**Mynydd y Gwynt Windfarm**

**Planning Inspectorate EN: 10020**

**Natural Resources Wales' Response on  
Landscape and Visual Amenity**

**Deadline X, 14 May 2015**

Drawing file: EN010020 / EN010020-000783-MYG-ES-Fig12.28 - B4518 above Llyn Clywedog Wireframe.pdf

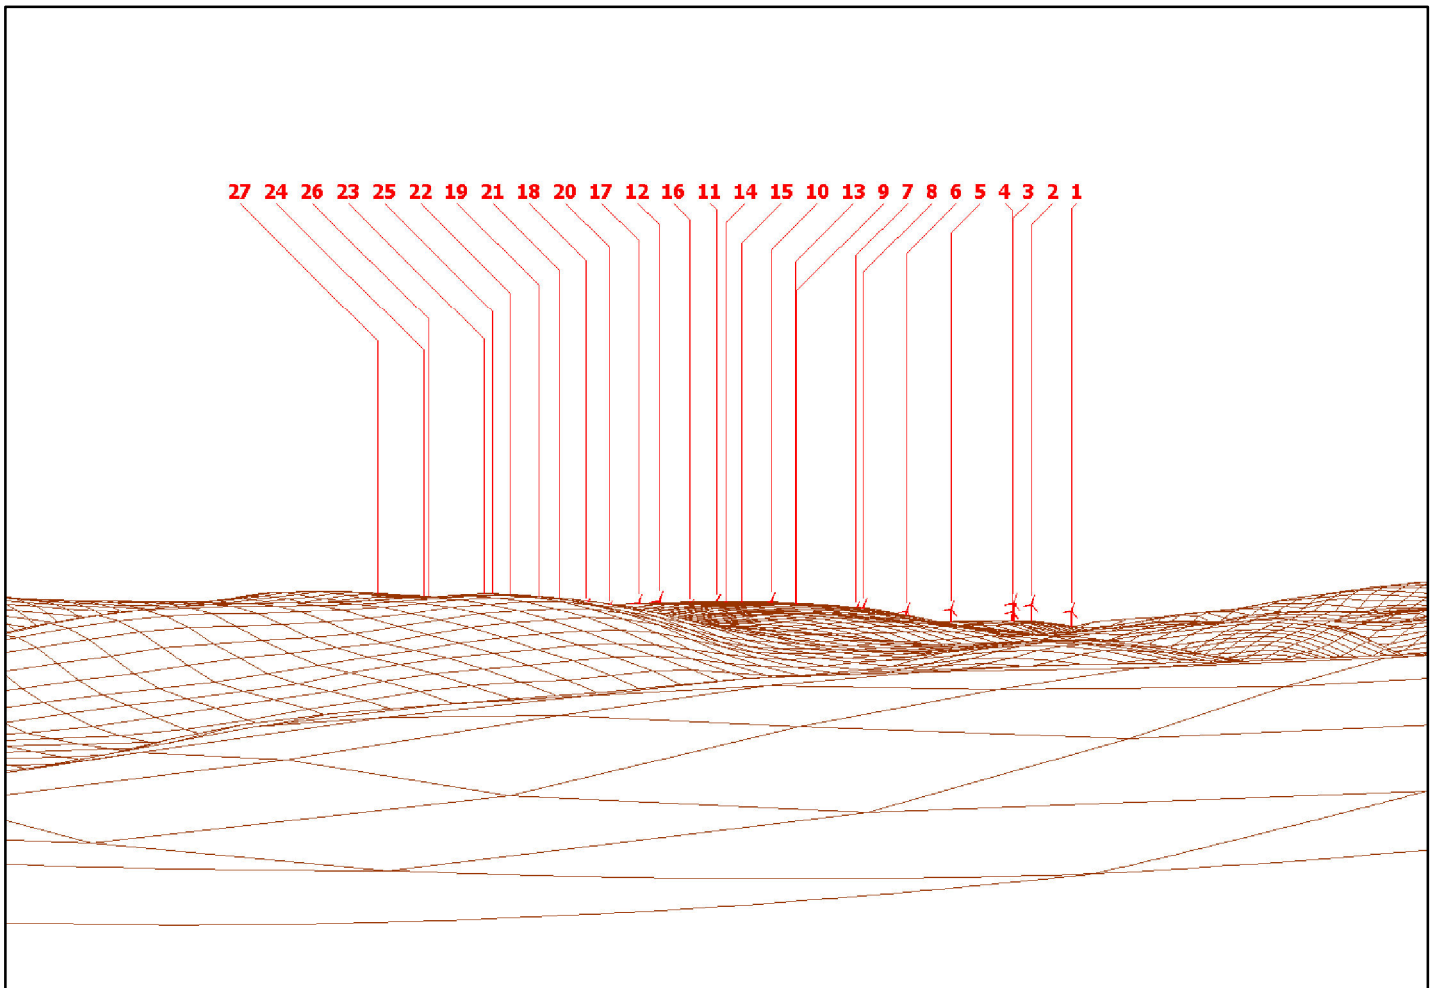
| ExA 2 <sup>nd</sup> round question no | ExA question | Simon White's evidence NRW Deadline VI 26 March 2015 | MyG's response Deadline VII 16/04/15 | NRW Comments on MyG response  |
|---------------------------------------|--------------|--|--------------------------------------|---|
|                                       |              |  |                                      | <p>In relation to Llyn Clywedog we agree that the proposal is not visible from the water surface but many visitors remain around its edge on higher ground from where the proposal is visible and it is a significant detractor in our view.</p> <p>In relation to other developments to the east, we note comments by others that the distant wind farms such as Bryn Titli and others are over emphasised in the photomontages such as from Viewpoint 1 on Plynlimon. We agree and this reinforces our point that the proposal would be significantly closer and therefore would have a larger and significantly greater adverse effect.</p> <p>The applicant equating the effects of this proposal on Pumlumon, the sources of the Severn and Wye and associated regional trails with the effects of the Carno windfarms on the A470 well illustrates why this proposal is more damaging. Interestingly, as an early wind farm Carno 1 is very discreetly located in relation to the village of Carno and the A470, despite the number of turbines, partly due to their size as well as siting. Carno 2, as a later, additional development with larger turbines, is significantly more visible to the road.</p> |
